1.5.18

RE: Renovation of 10 Mellen St., Portland Me.

Responses to email plan review queries dated 12.22.18:

A1.1

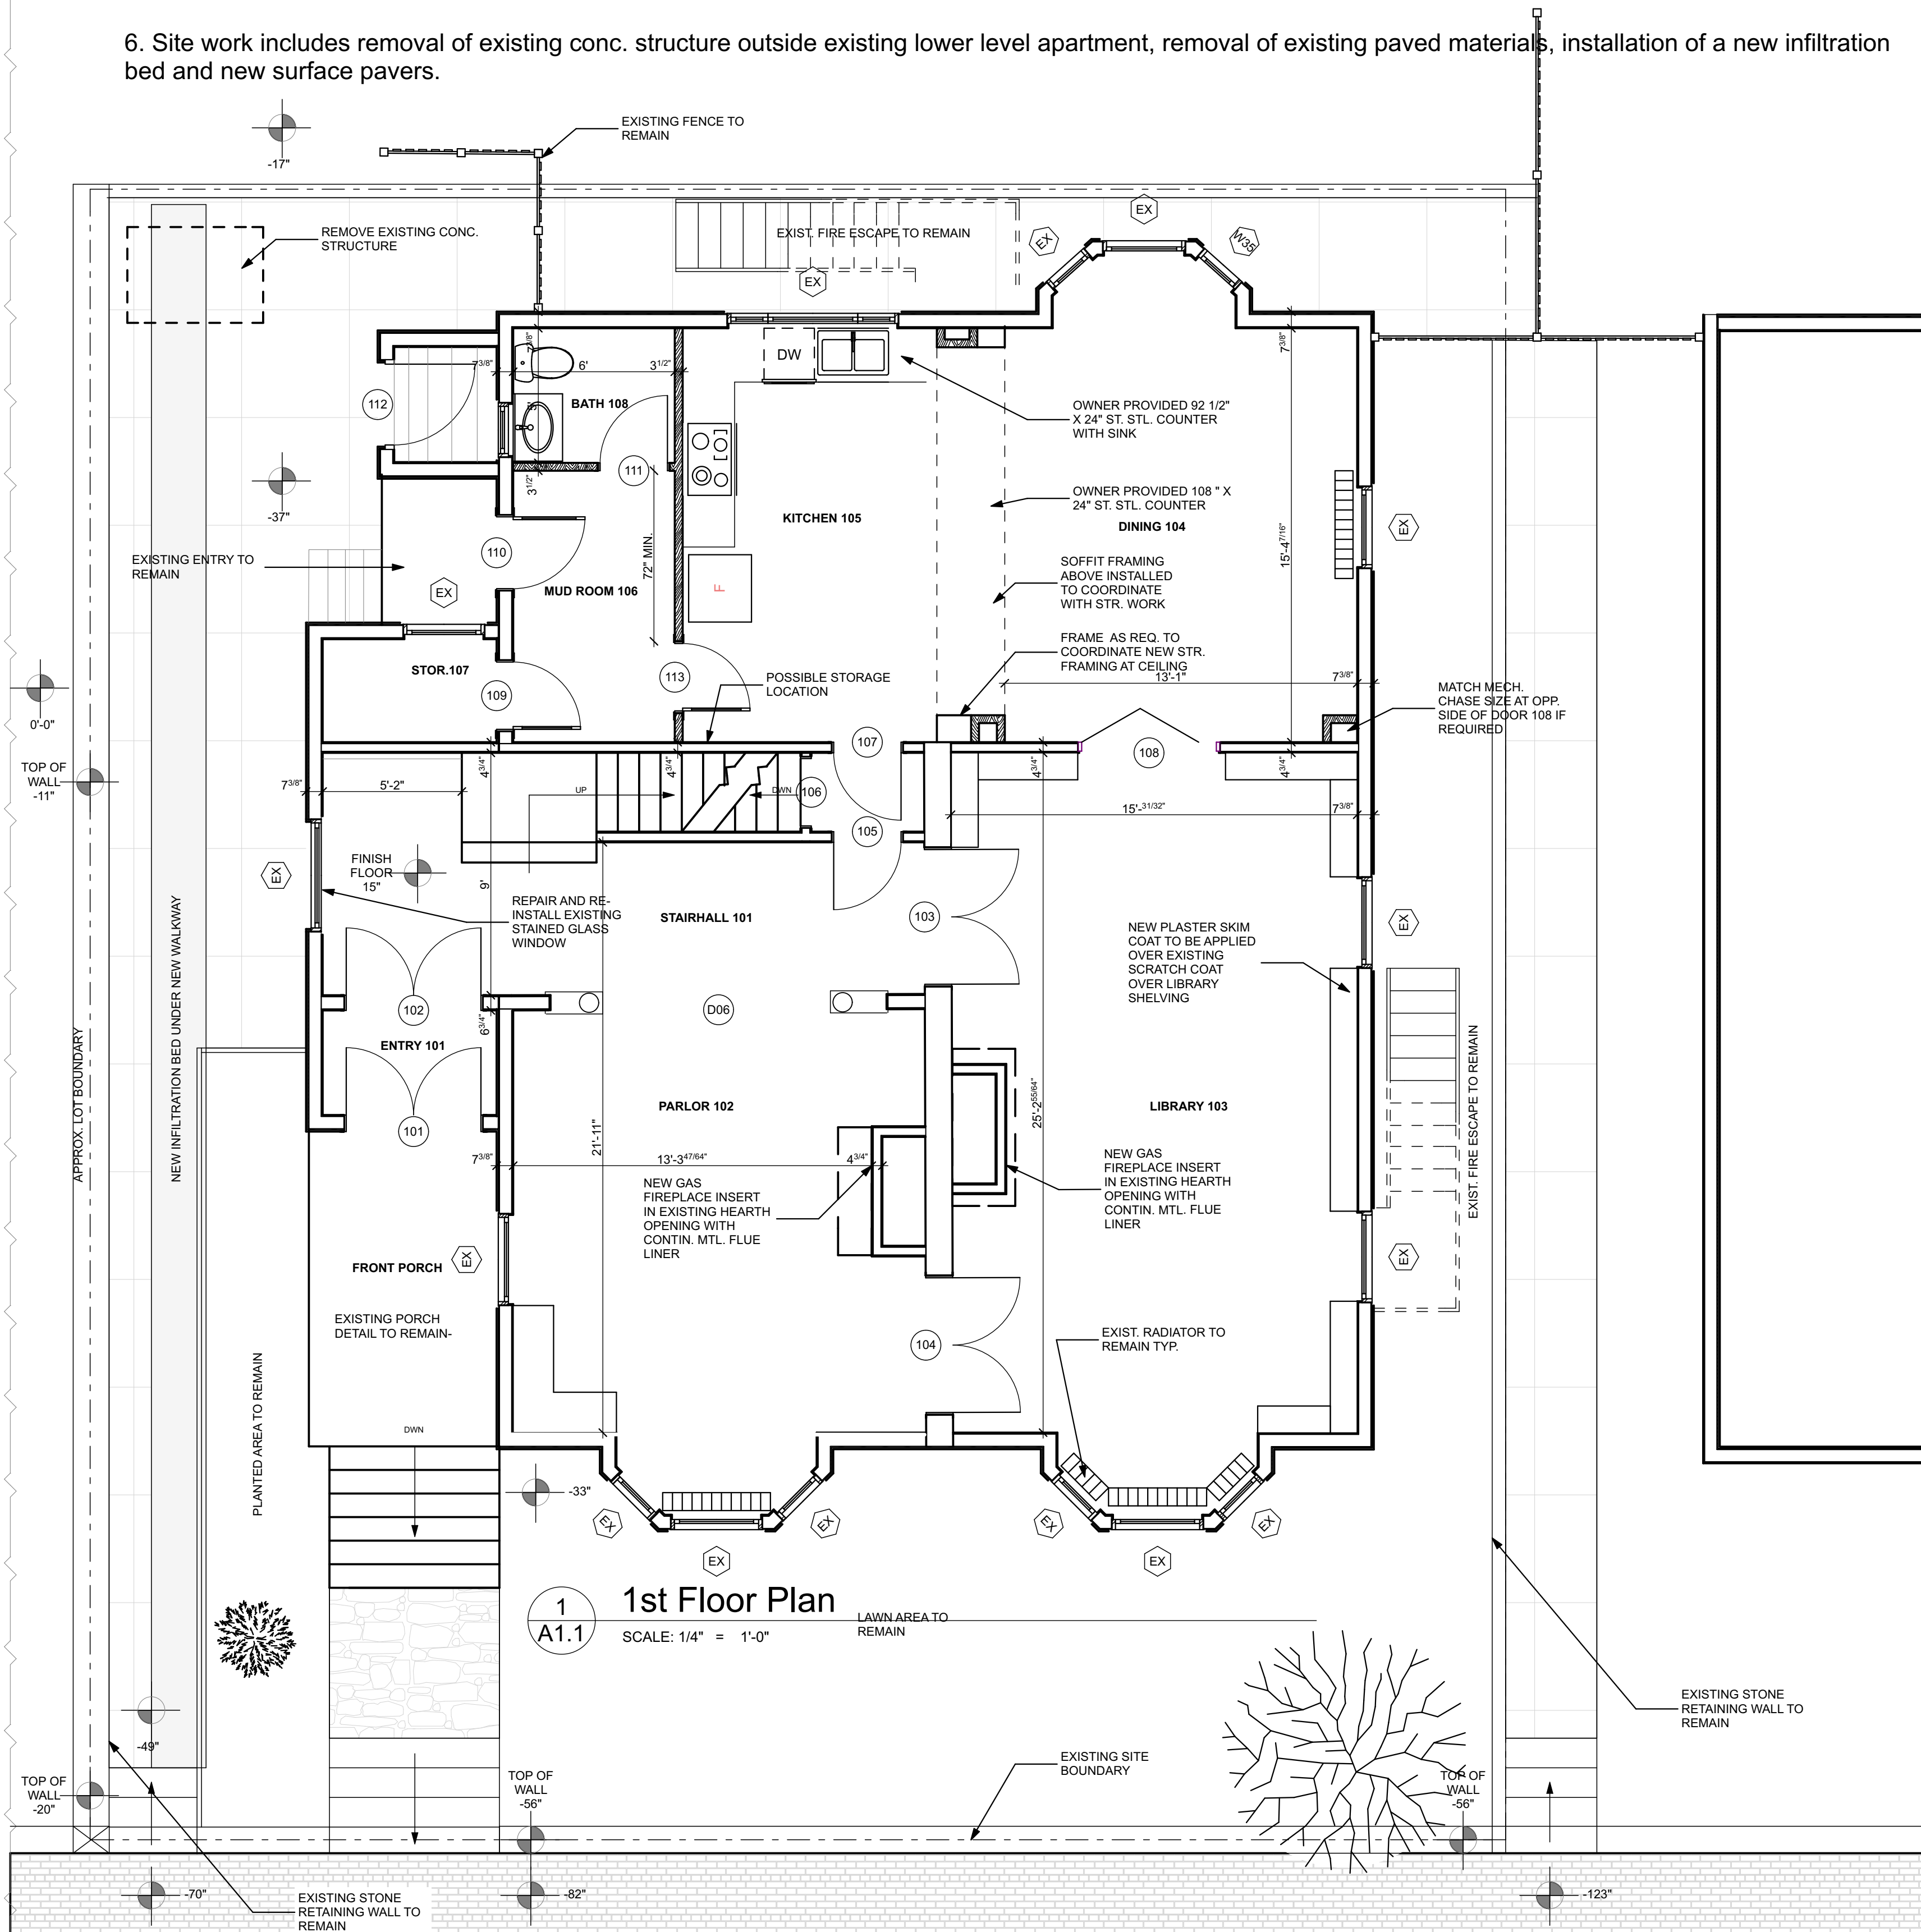
1. The structural notes regarding exterior sheathing have been revised and the structural drawings are attached.
2. The dryer vent at the basement level will be run within the room and NOT as shown in the permit drawings or penetrating 1 hr. partitions. Please refer to attached revised basement plan notation.
3. A note has been added regarding the shaded walls. The walls are existing open 2 x 4 @ 16" studs that we are enclosing with new 5/8" sheetrock.
4. The note regarding the temporarily enclosed porch to remain is intended as a place-holder for a future permit and Historic District Review. While we may improve structure we will not be affecting exterior appearance prior to an HDRC approval.
